**Subject: Request for Modification to Individual Section 404 and Section 401 Water Quality Certification** for the proposed improvements to NC 24 from 2.8 miles east of I-95 to SR 1853 (John Nunnery Rd.) in Cumberland County. Federal Aid Project No. STPNHF-F-8-2(17), TIP No. R-2303A. Debit \$570.00 from WBS 34416.

References: Section 404 Individual Permit signed December 20, 2012  
(SAW-1992- 03237)  
Section 401 Water Quality Certification issued September 24, 2012 (20120240)

The purpose of this letter is to submit corrected information for modification of the Clean Water Act (CWA) Section 404 Individual Permit (IP) and Section 401 Water Quality Certification for R-2303A.

Permit Drawing
Sheet 23 of 40
Revised 9/23/2015

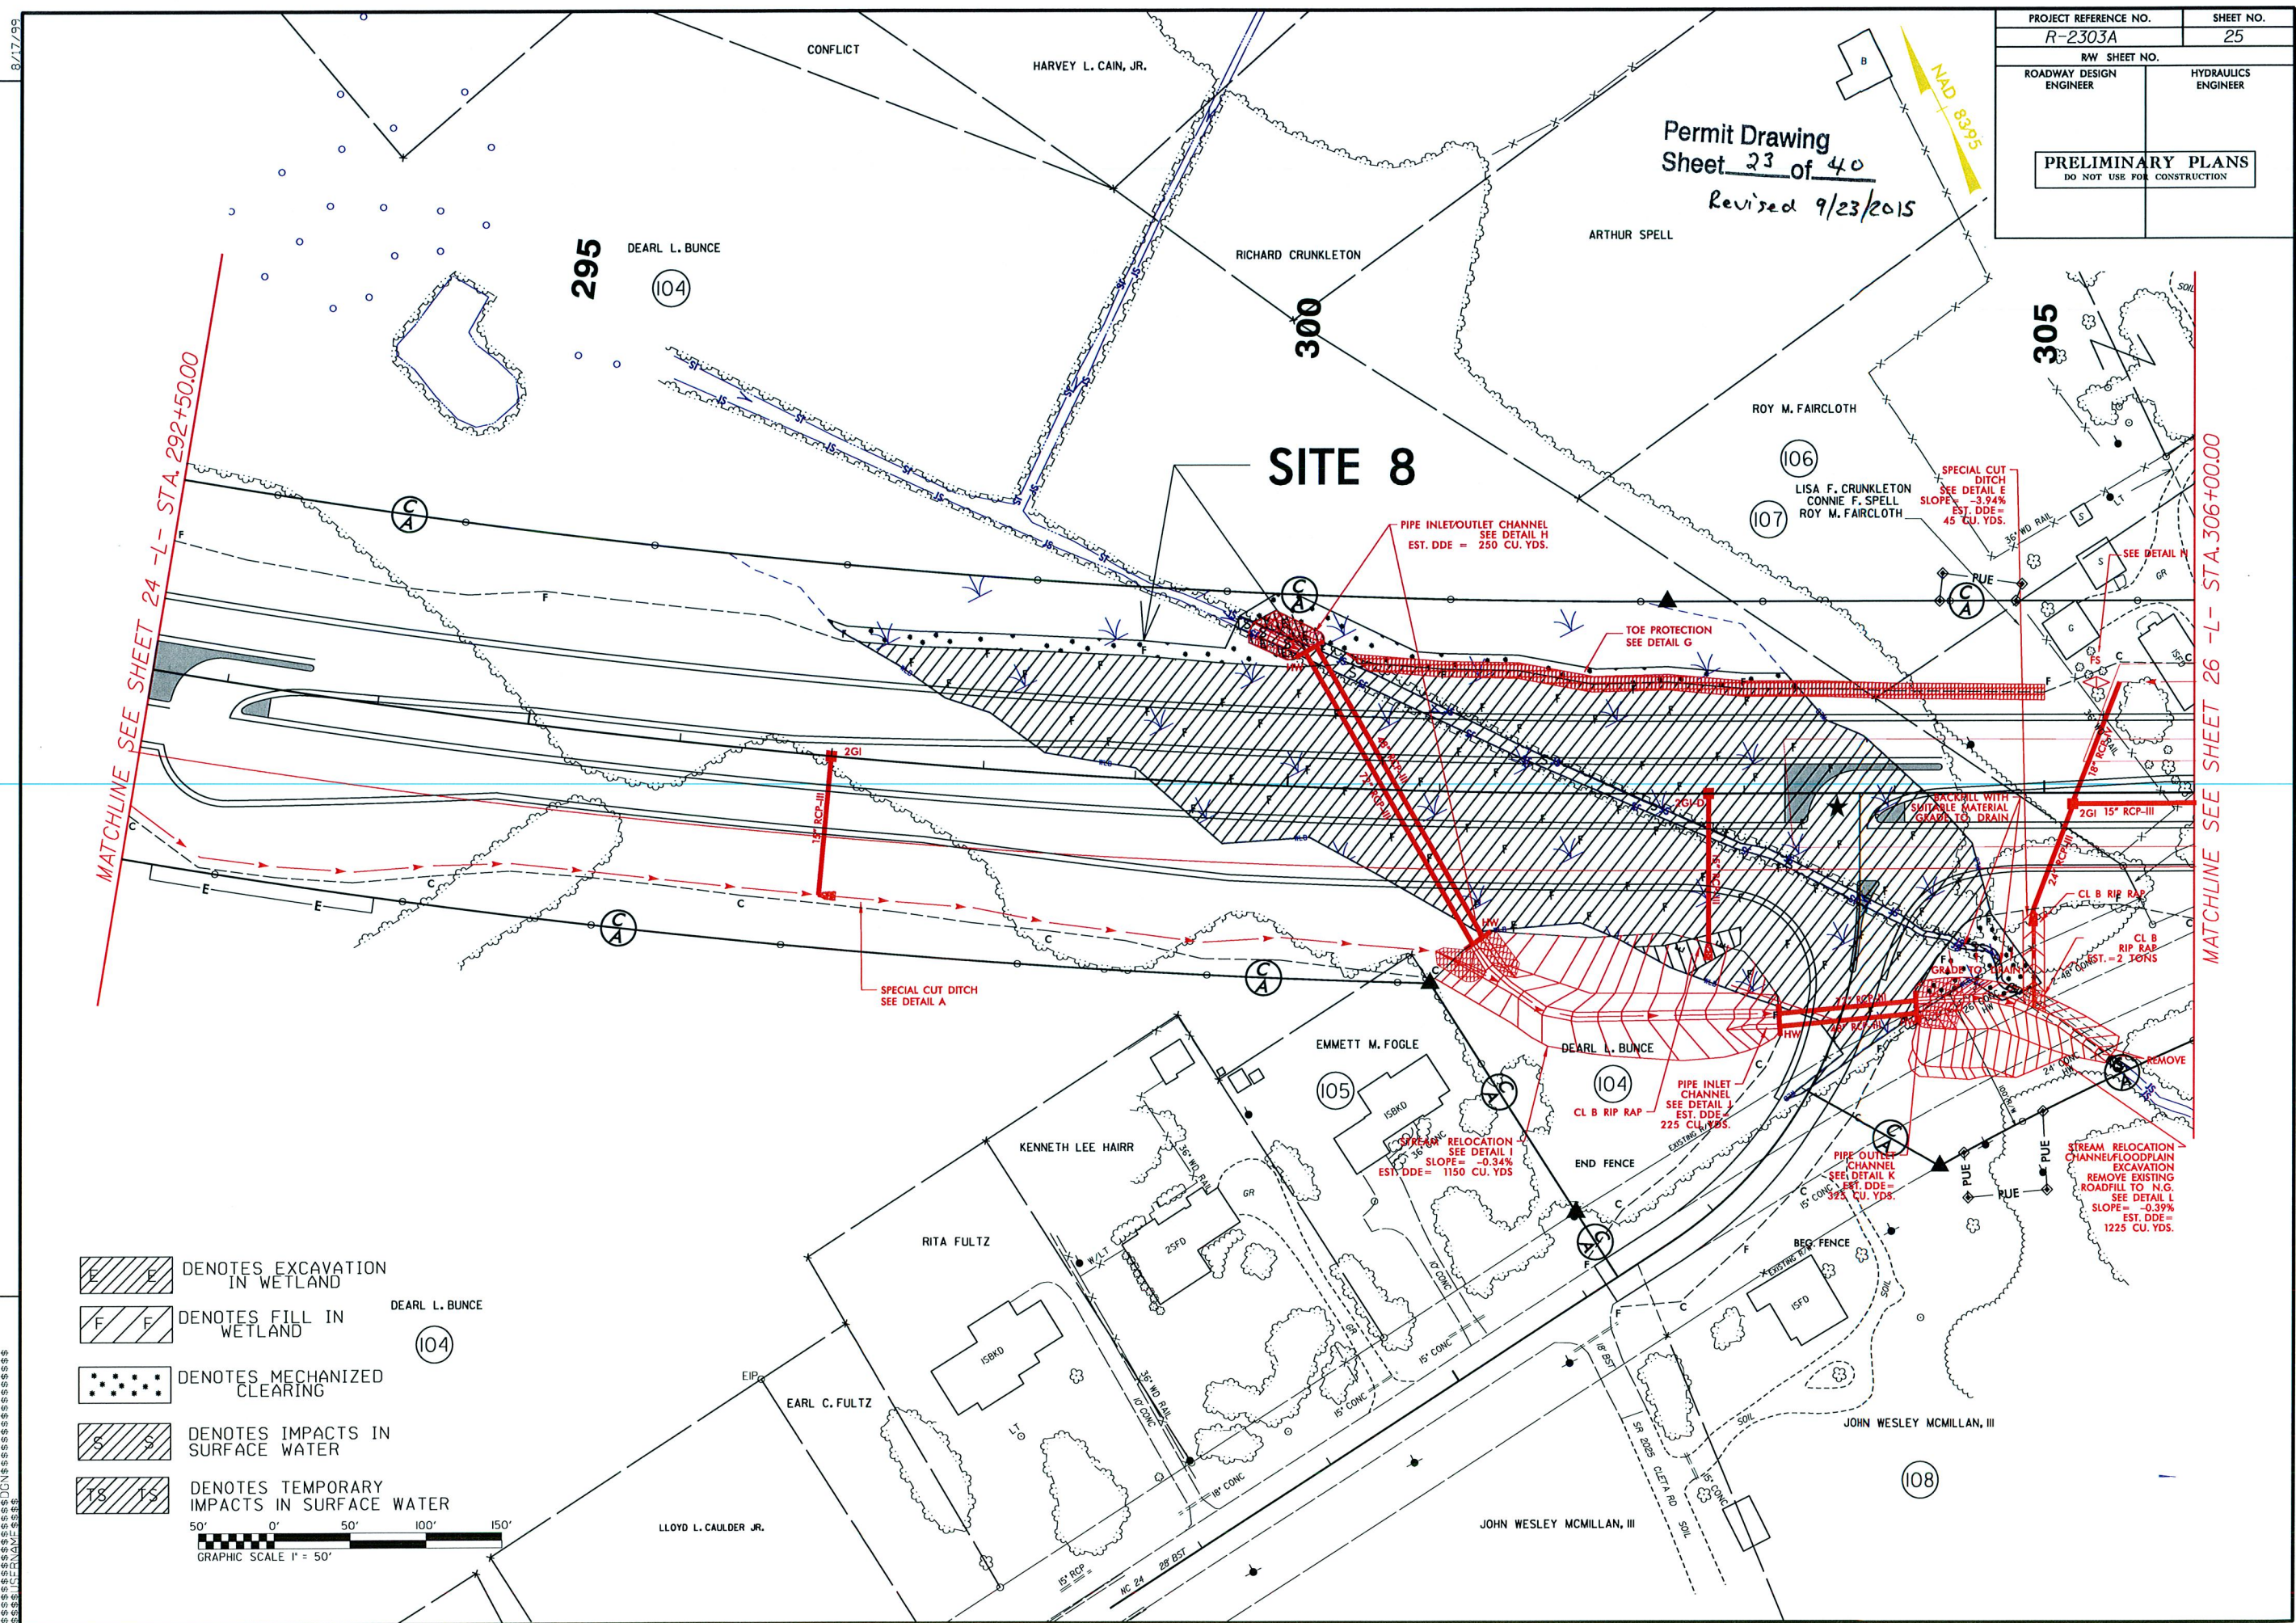
NCDOT has determined that the wetland impacts at Site 8 of R-2303A were tabulated incorrectly in the application, and that additional excavation and mechanized land clearing need to be accounted for. Attached you will find revised plan sheets and summary sheets which show an additional 0.02 acre of excavation and 0.03 acre of mechanized land clearing. The total wetland impacts for the project are thereby increased by 0.05 acre. Site 8 involves riparian wetlands.
